**Our ref:** AN/2024/135649/01-L01  
**Your ref:** H18-0463-24  
**Date:** 20 June 2024

**Change of use from hotel Class C1 to residential Class C3 including the creating of 15 residential units  
Bridge Hotel, 4 Bridge Road, Sutton Bridge, Spalding, PE12 9UA**

**Environment Agency position**

DWGS NO.:
723-04-C

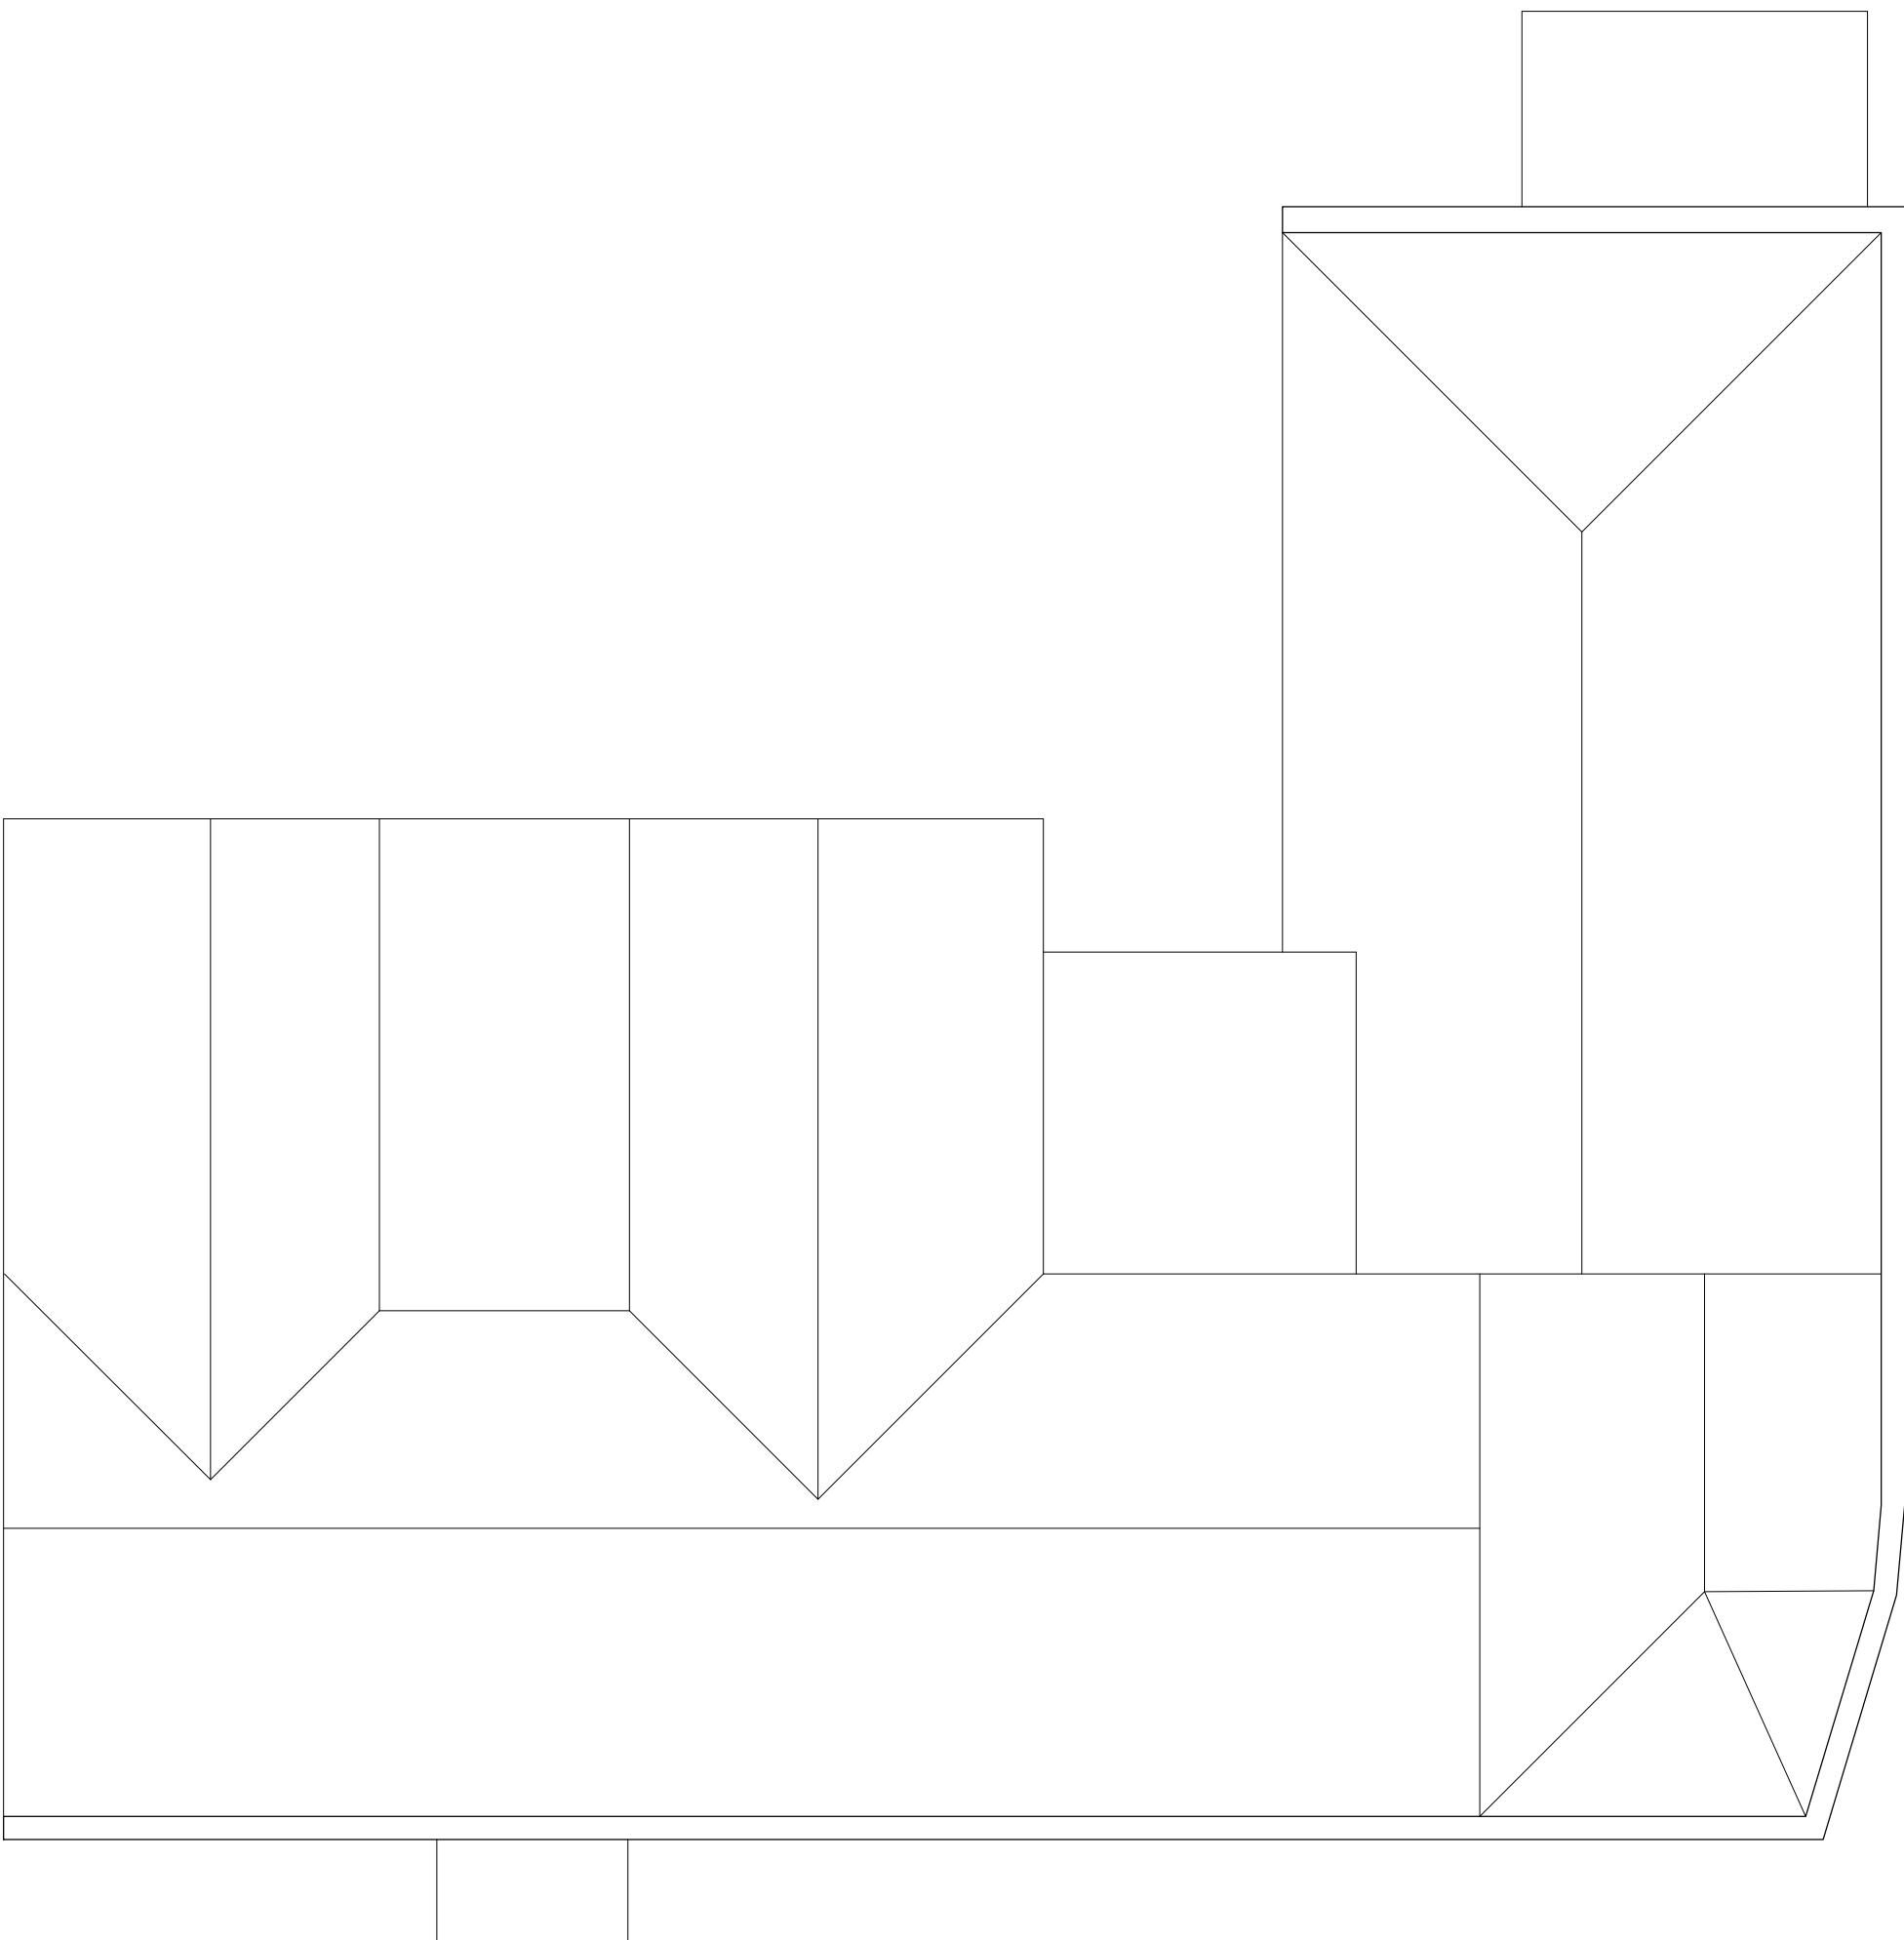
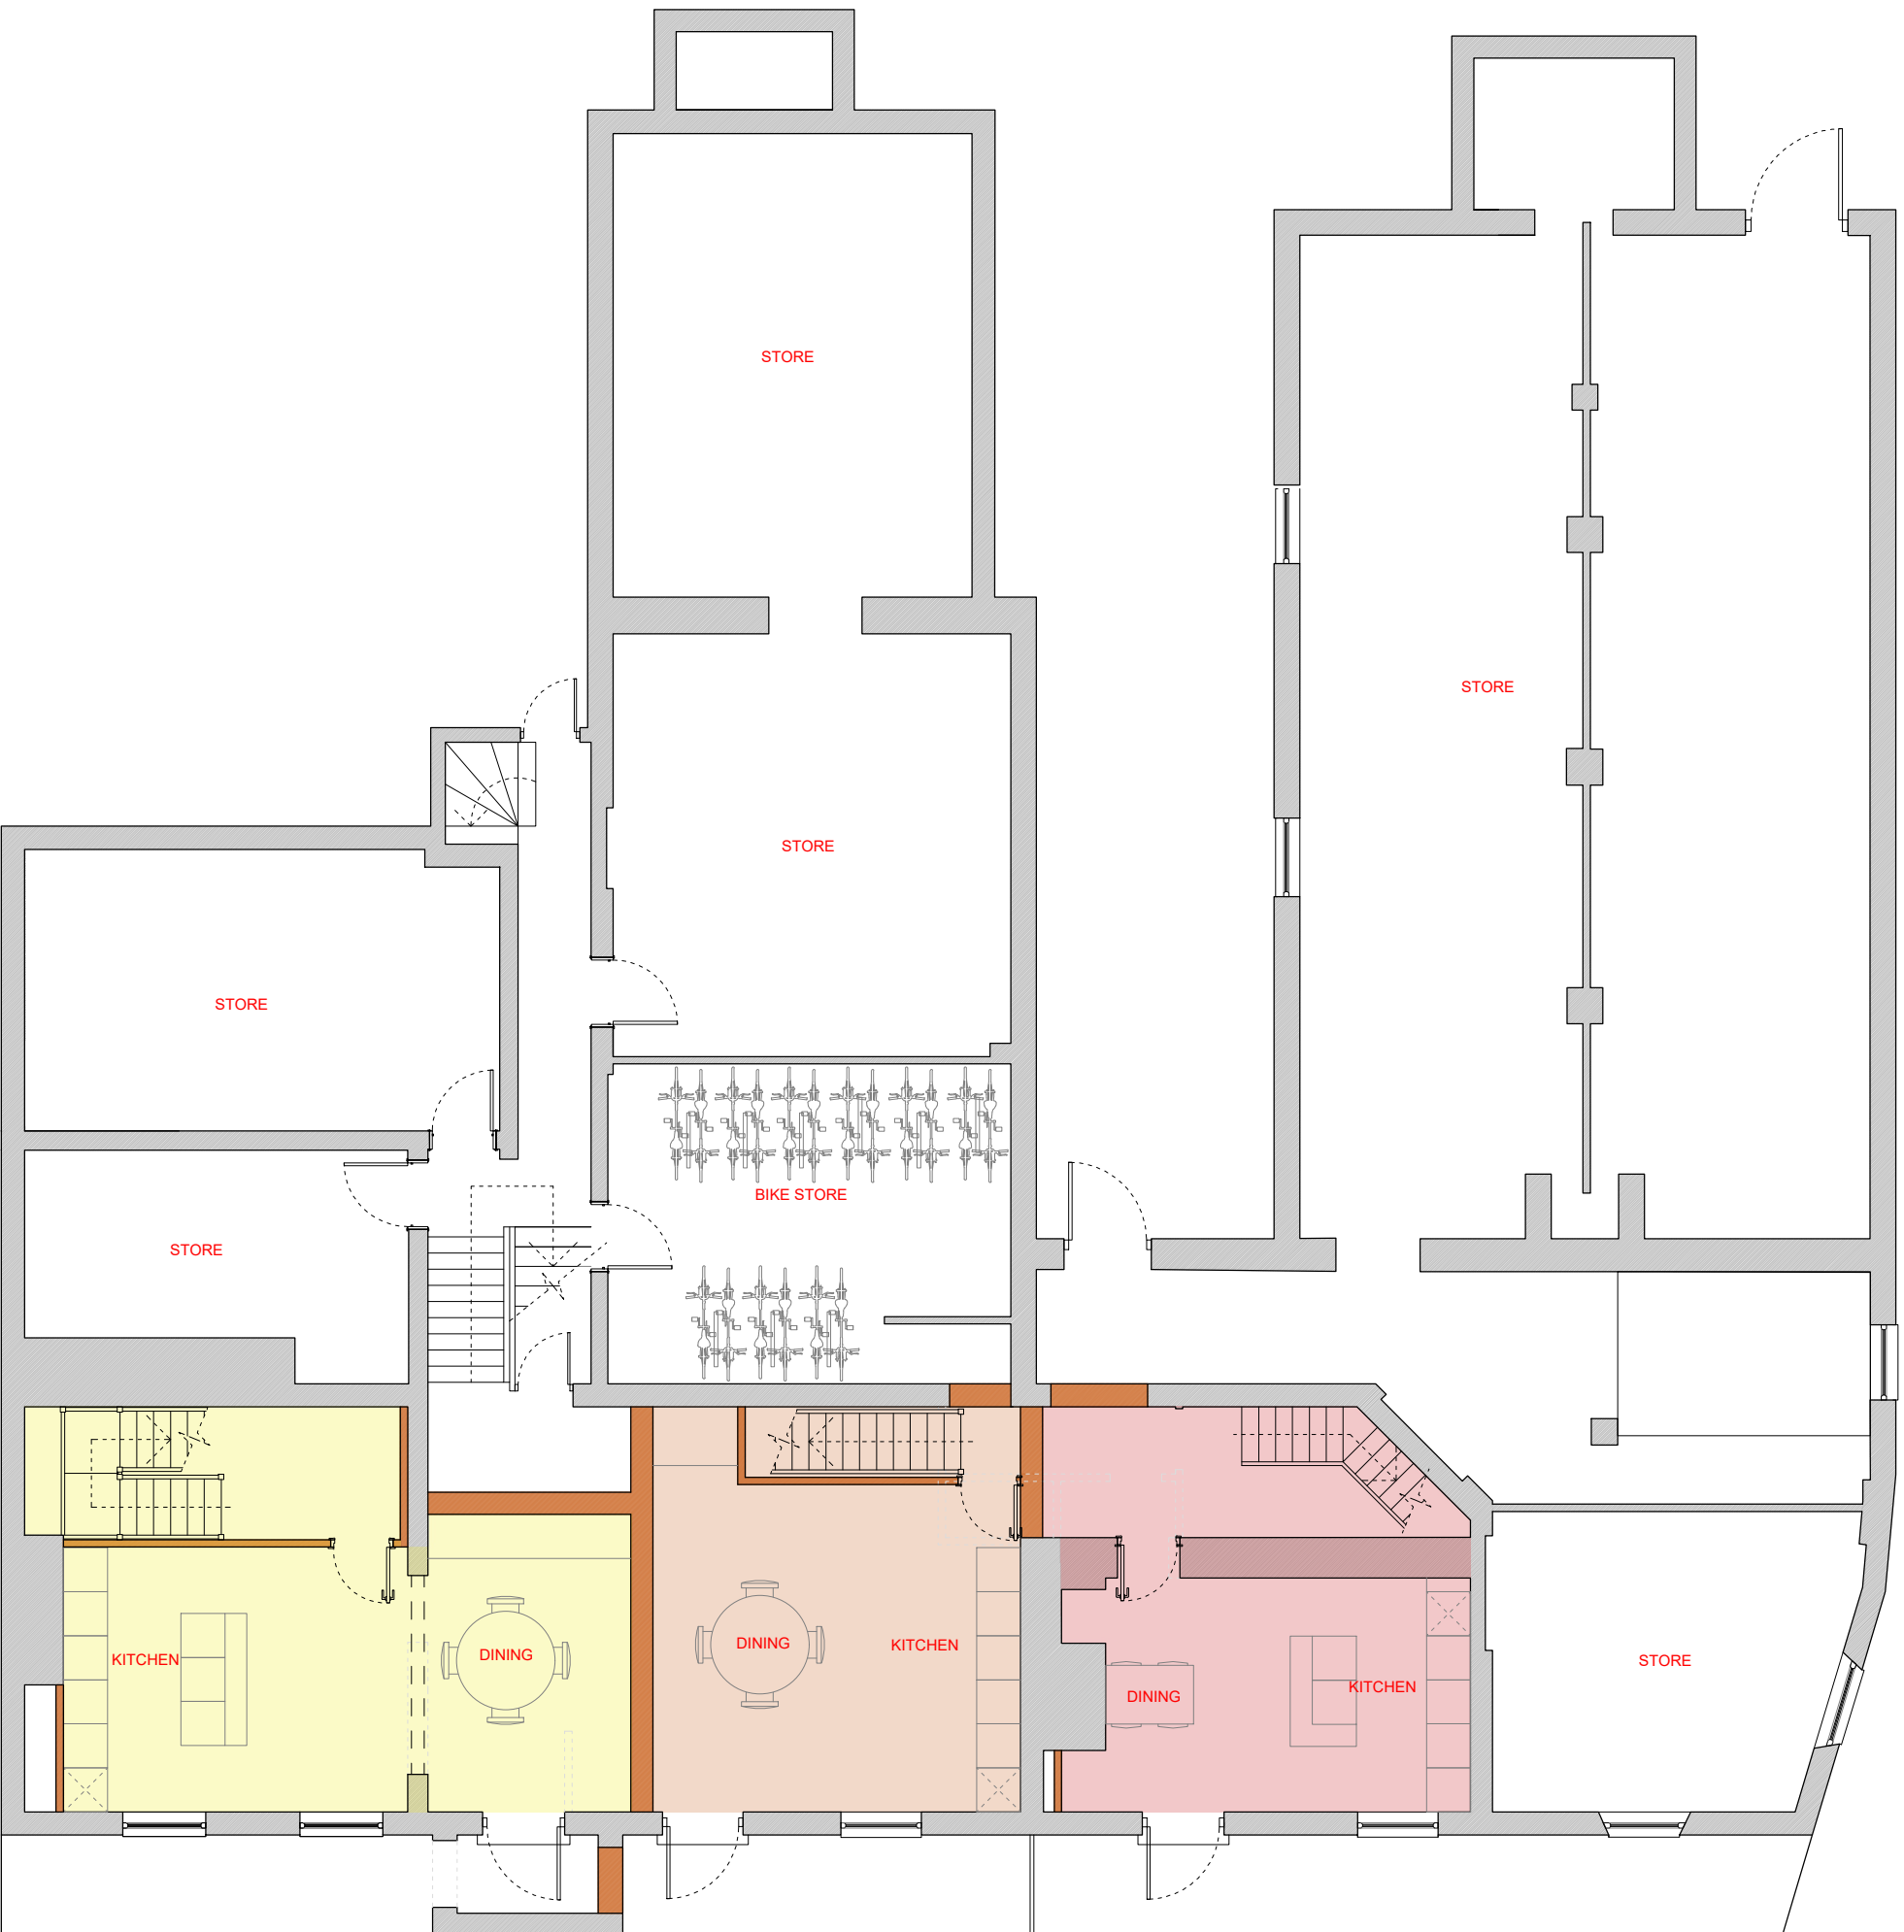
The submitted drawing dated 20 May 2024, ref: '723-04-C', prepared by Clayton Architecture Limited proposes self-contained ground floor flats, below the predicted flood level, with kitchen/dining spaces proposed at the basement level. In accordance with Policy 4 of the South East Lincolnshire Local Plan 2011-2036, we do not consider the proposed self-contained ground floor residential accommodation to be appropriate due to the flood risk at this site.

To overcome our objection, the applicant should submit evidence to demonstrate that the proposal will not pose a risk to life and property as highlighted above.
